October 1, 2015

Re: Status of Improvement Permit Application # 15-5-36922

An attempt was made to evaluate your property for the purpose of issuing an Improvement Permit. The evaluation could not be completed for one or more of the following reasons.

- PLOT PLAN FOR -
CATES BUILDING, INC.
- SUBDIVISION -
TINGEN POINTE - PHASE 6

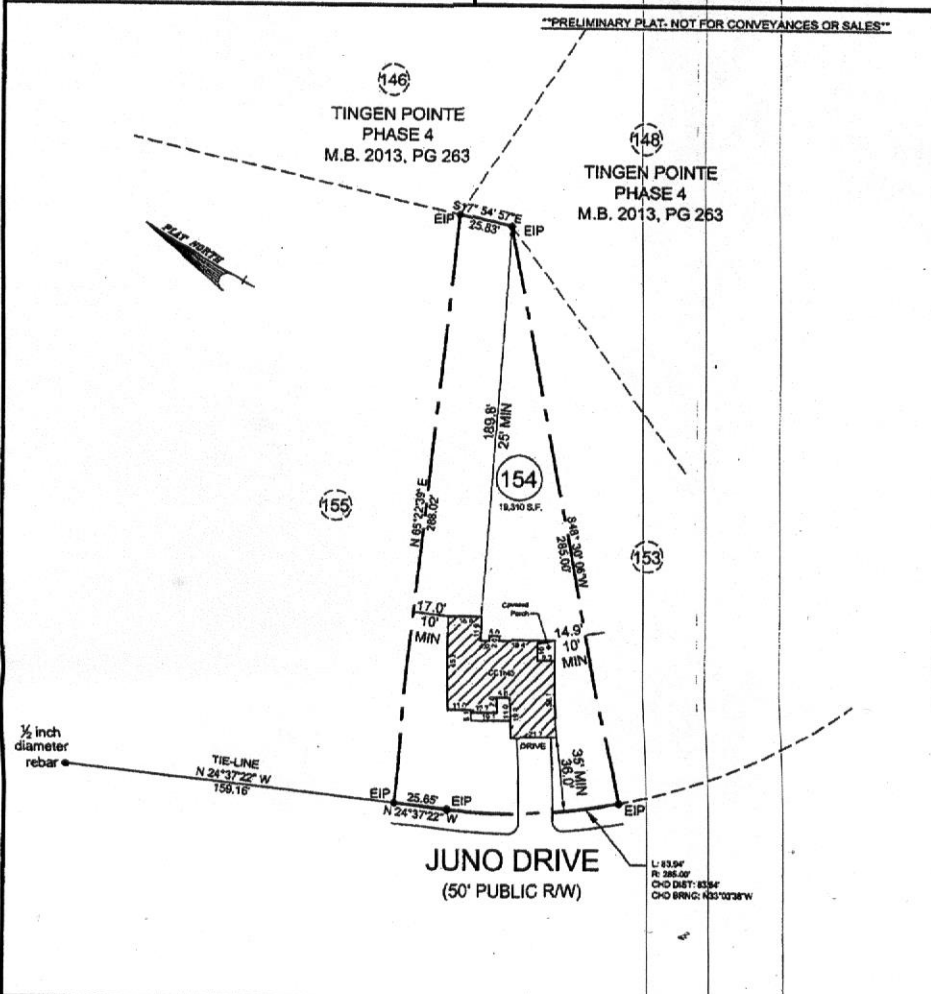
- 1. Use pink flags to mark property lines and irons that are set by surveyor need to be visible**
- 2. Use orange flags to mark house corners (*\$25.00 fee incurred*)
- 3. Directions not clear to property (*\$25.00 fee incurred*)
- 4. Property needs only brush or vegetation removed
- 5. Driveway not shown on site plan
- 6. Backhoe pits required
- 7. Other – Revise site plan to match soil consultant’s proposal.**
